From: Andrew de Croos [REDACTED]
Subject: RE: Planning Consultation on: BE/170/16/RES - Bognor (13174)
Date: 2 March 2017 at 14:55
To: Thomas Callaway Thomas.Callaway@arun.gov.uk
Cc: Gareth Crowther [REDACTED] Andrew Rowe [REDACTED]

I'd be grateful you could advise whether the drainage information submitted to date is sufficient to allow construction to commence on site given conditions 5 & 6 are pre-commencement conditions.

HYDROBRAKE CHAMBER (PLAN)

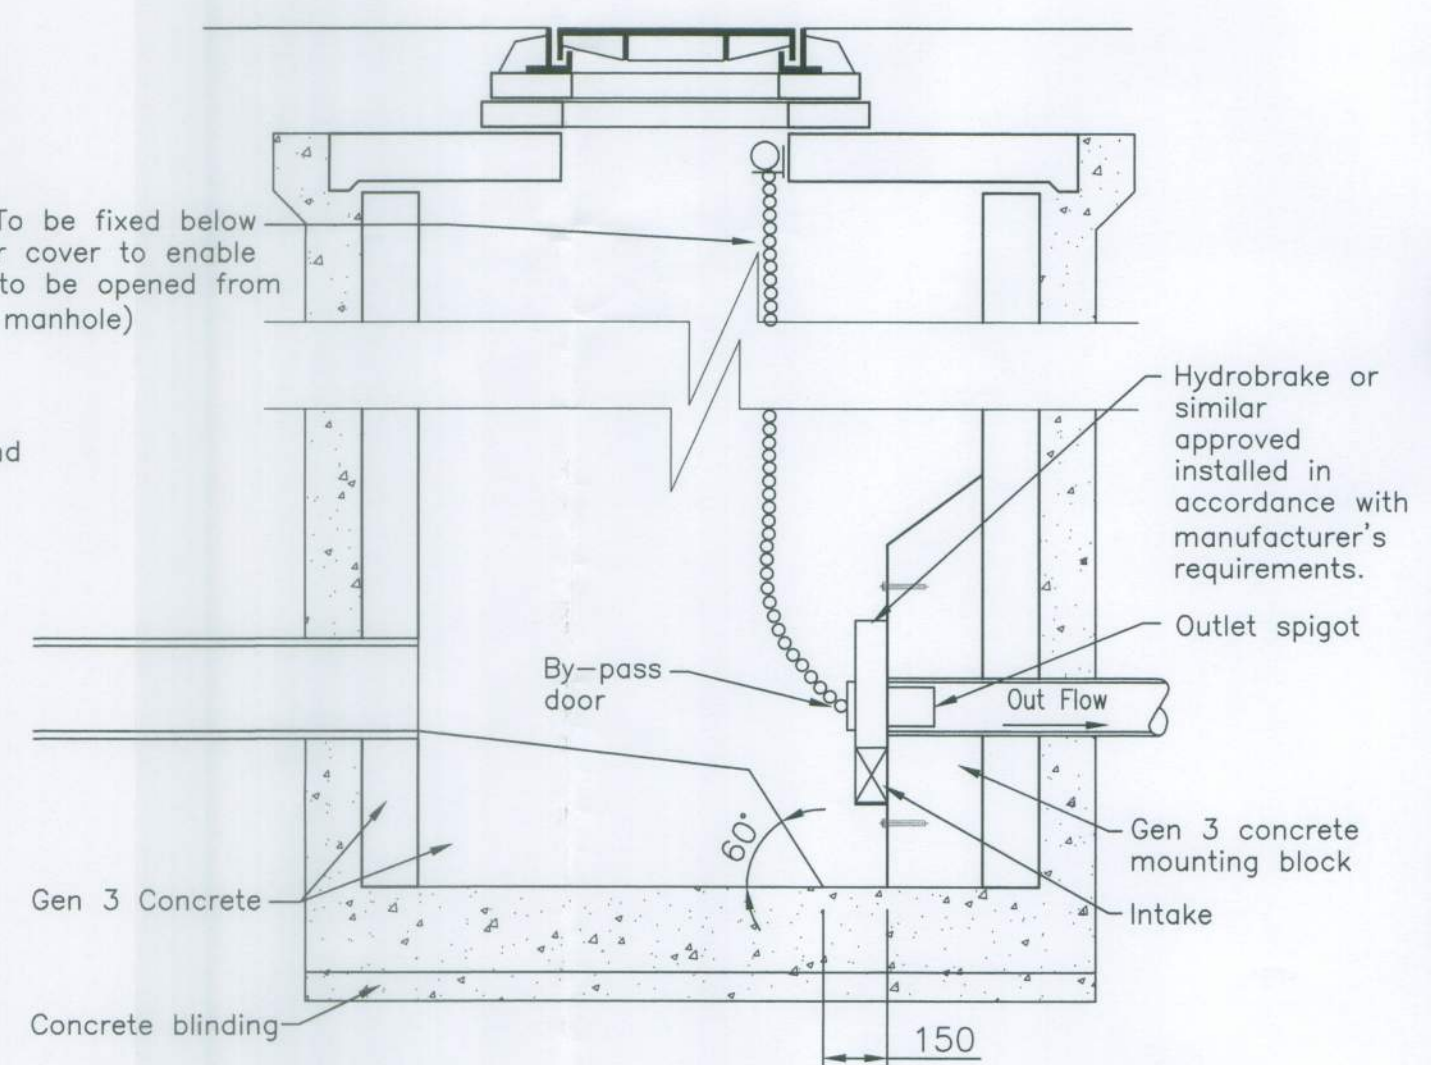
I would need the supporting calculations showing that the storage is there without flooding being caused in the 1 in 100 year storm event plus climate change allowance. I see that the Hydro Brake details show the allowable discharge rate to be 43 l/s, which is acceptable.

I've attached the supporting Micro Drainage calculations for the 1 in 100 year plus climate change event. These calculations will also be submitted through the planning process.
